**WEST SUSSEX COUNTY COUNCIL
HIGHWAYS AND TRANSPORT SERVICES CONSULTATION**

DATE: 27/02/2008

SUBJECT: R/46/08 - Demolition of existing bungalow and erection of 3no. dwellings.

22, Mill Lane, Rustington, West Sussex

Scale 1:500 @ A3

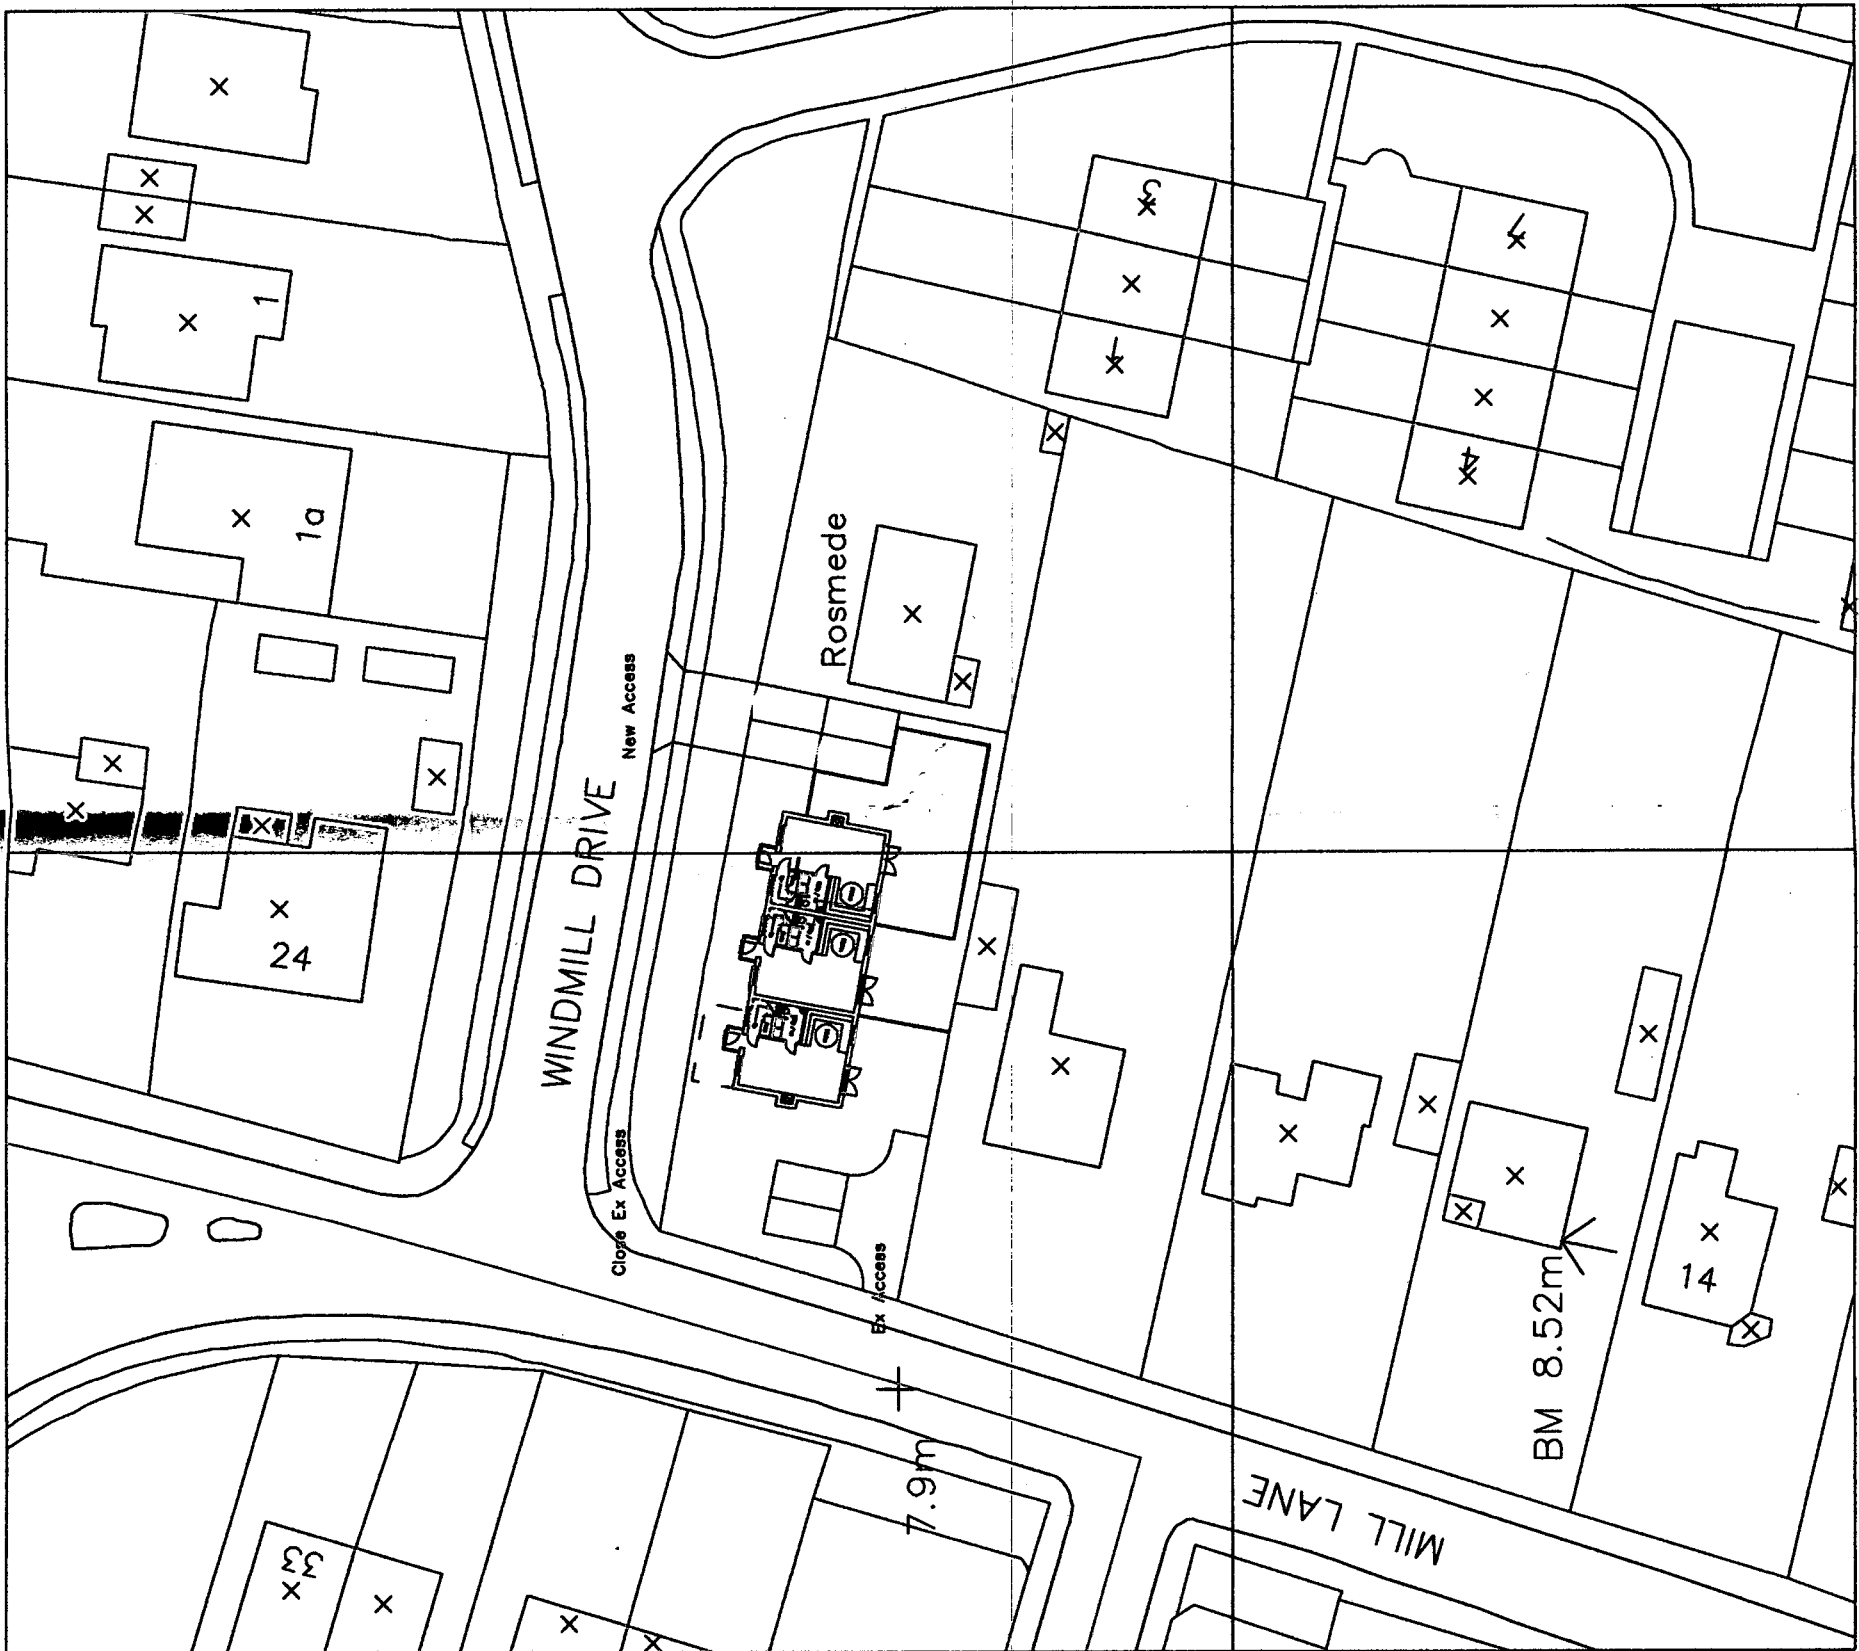
From an inspection of the plans alone, there is no apparent visibility issue at the point of access onto Windmill Drive. The new access point is at the rear of the existing property. Visibility for drivers should be taken into account. The applicant should provide visibility splays of 2.2m by 2.2m if planning permission is granted. In addition pedestrian visibility splays should also be taken into account. Splays of 2 metres by 2 metres should also be supplied either side of the proposed vehicular access onto Windmill Drive. Due to the quiet nature of the area the development is planned for, I would not foresee there being grounds for concern. I have also checked our most recently available verified accident records, which reveals there have been no personal injury accidents in the vicinity of the existing point of access, indicating a low risk of highway safety issues with this proposal.

No development shall be commenced until visibility splays of 2.2 metres by 2.2 metres have been provided at the centre of the proposed site vehicular access onto Windmill Drive. These visibility splays shall thereafter be kept free of all obstructions over a height of 0.6 metres above adjoining carriageway level.
